From: Laura Gibbons <Laura.Gibbons@arun.gov.uk>
Sent: 08 February 2022 08:39
To: Planning.Responses <Planning.Responses@arun.gov.uk>
Cc: Anita Gardner <Anita.Gardner@arun.gov.uk>
Subject: RE: Planning Consultation on: CM/4/22/DOC

Engineers Comments Regarding Condition 8

Application No: CM/4/22/DOC

Description of Works: Approval of details reserved by condition imposed under ref CM/64/19/PL relating to Condition Nos 8 - as-built drawings and 14 - energy efficiency.

As-built Survey

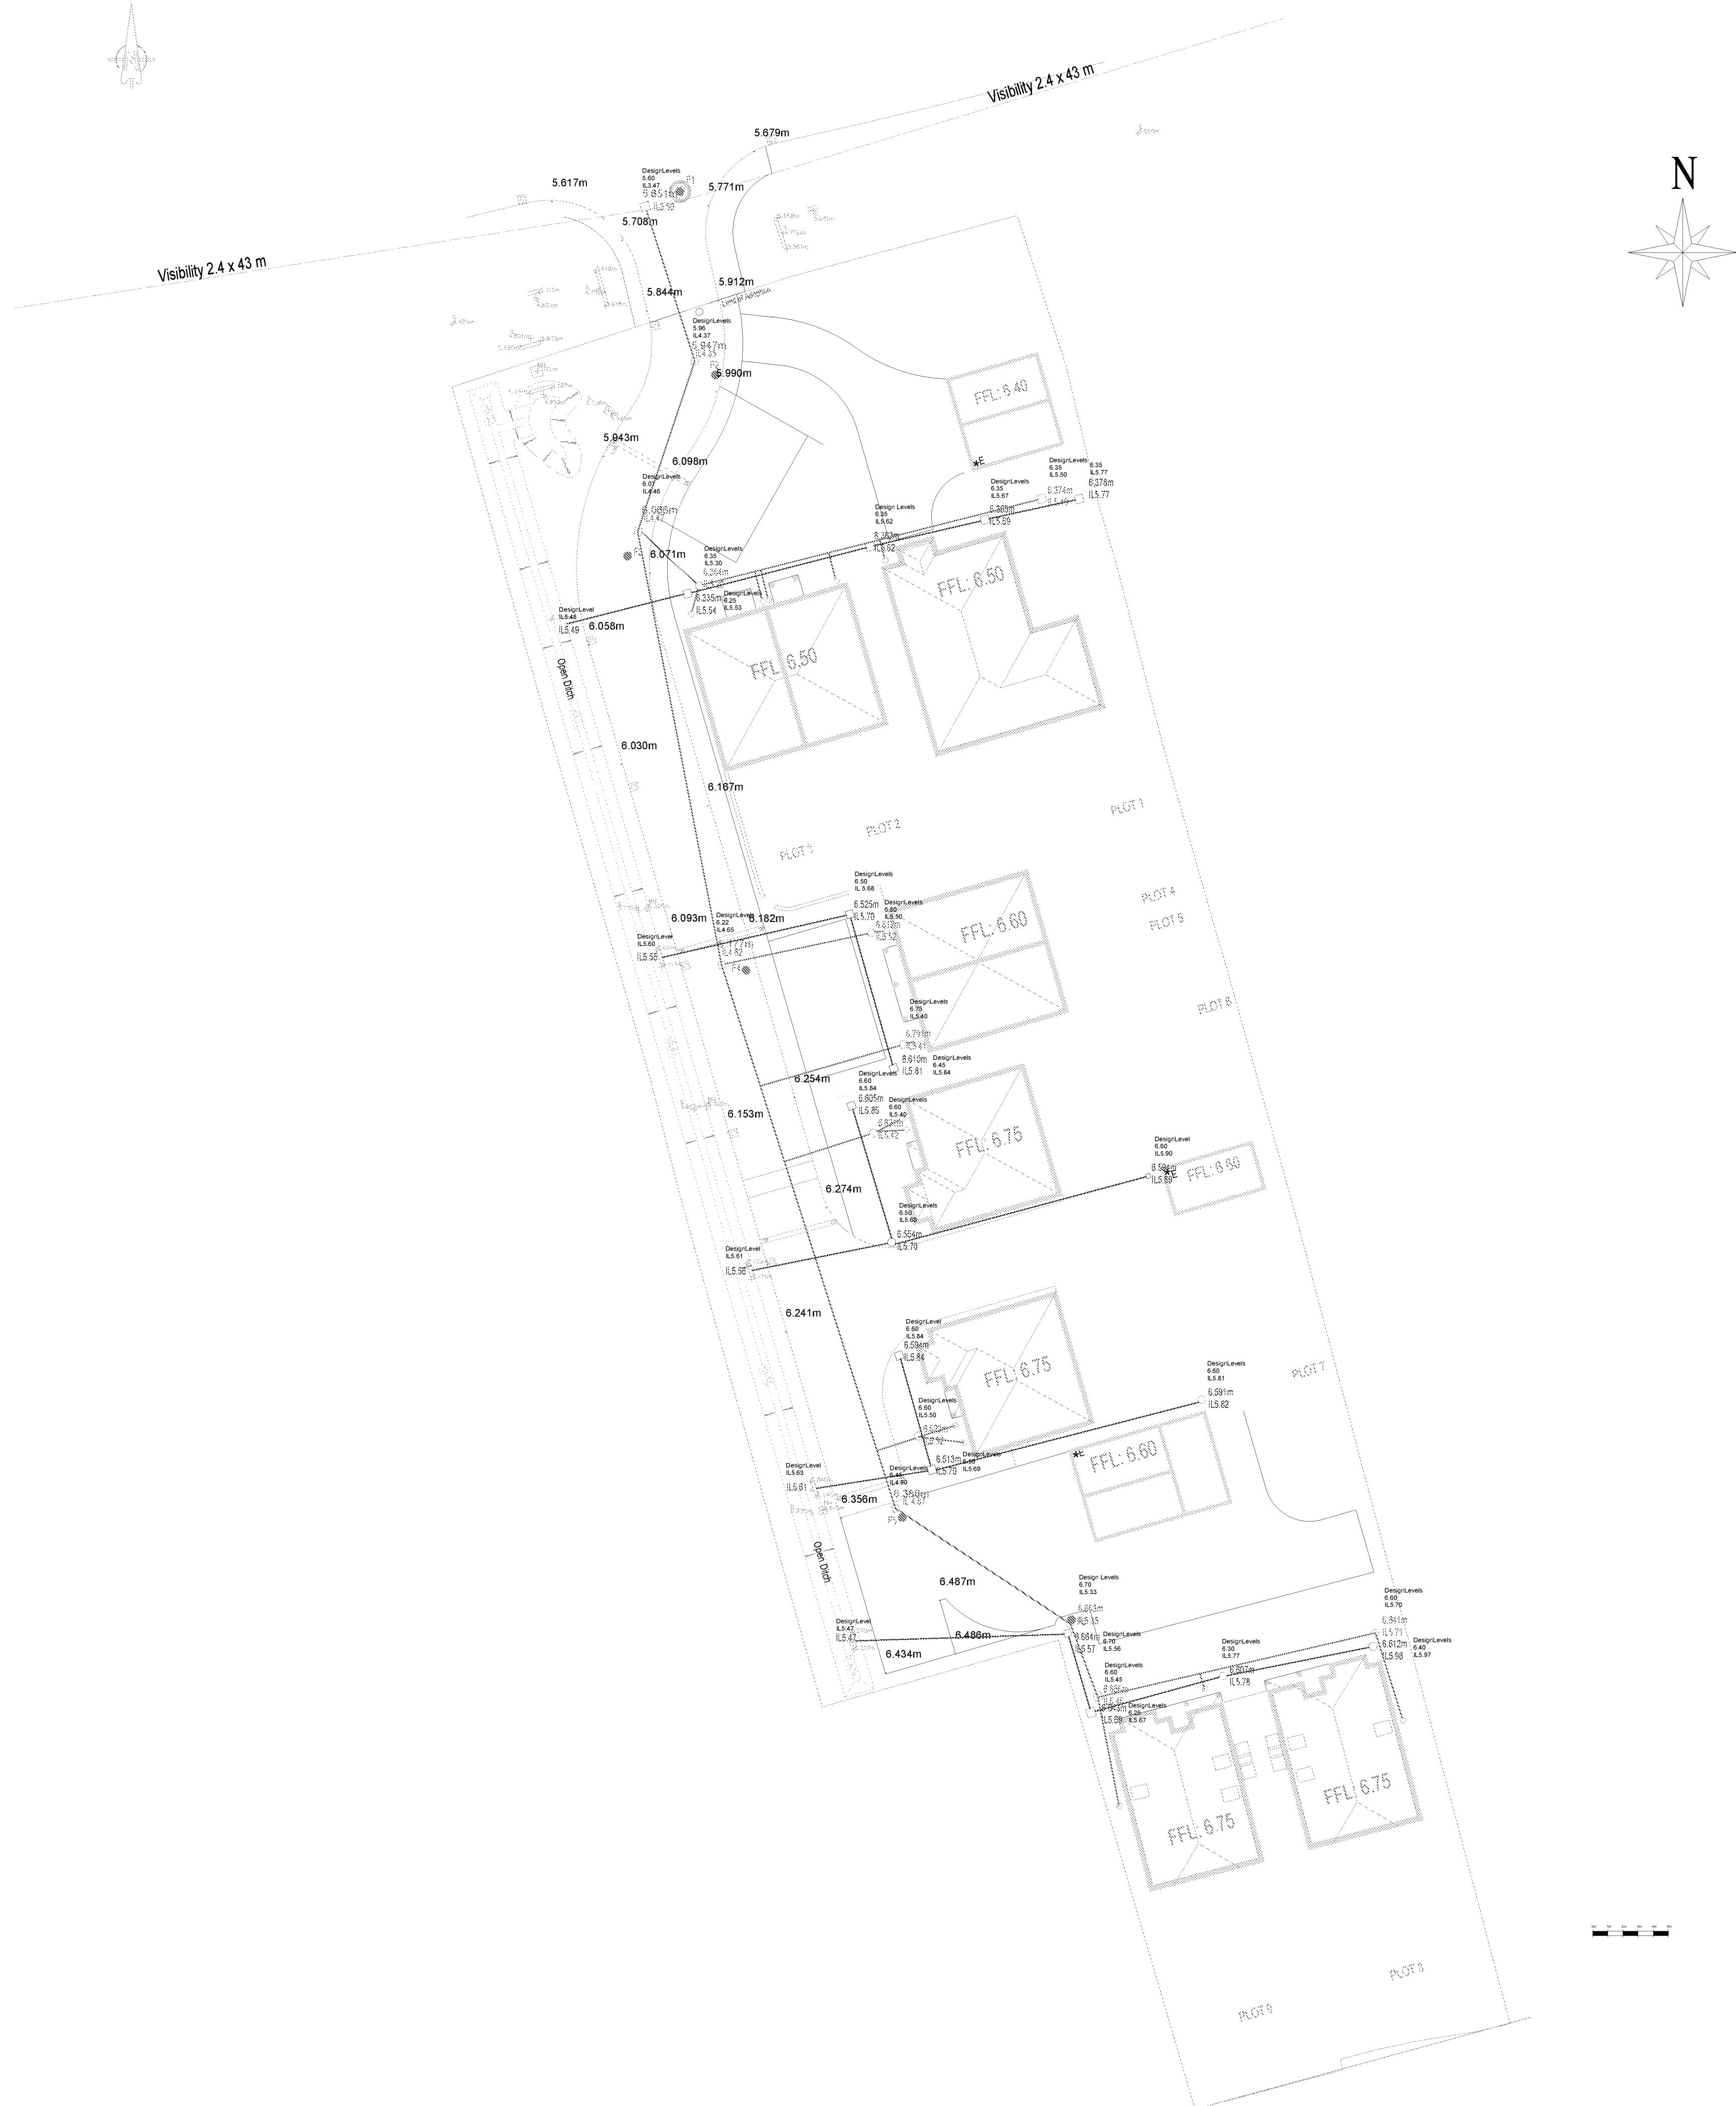
Please provide details of the inspection and verification of control chambers. I.e. surveyed invert and cover levels and good receipts for flow control devices.
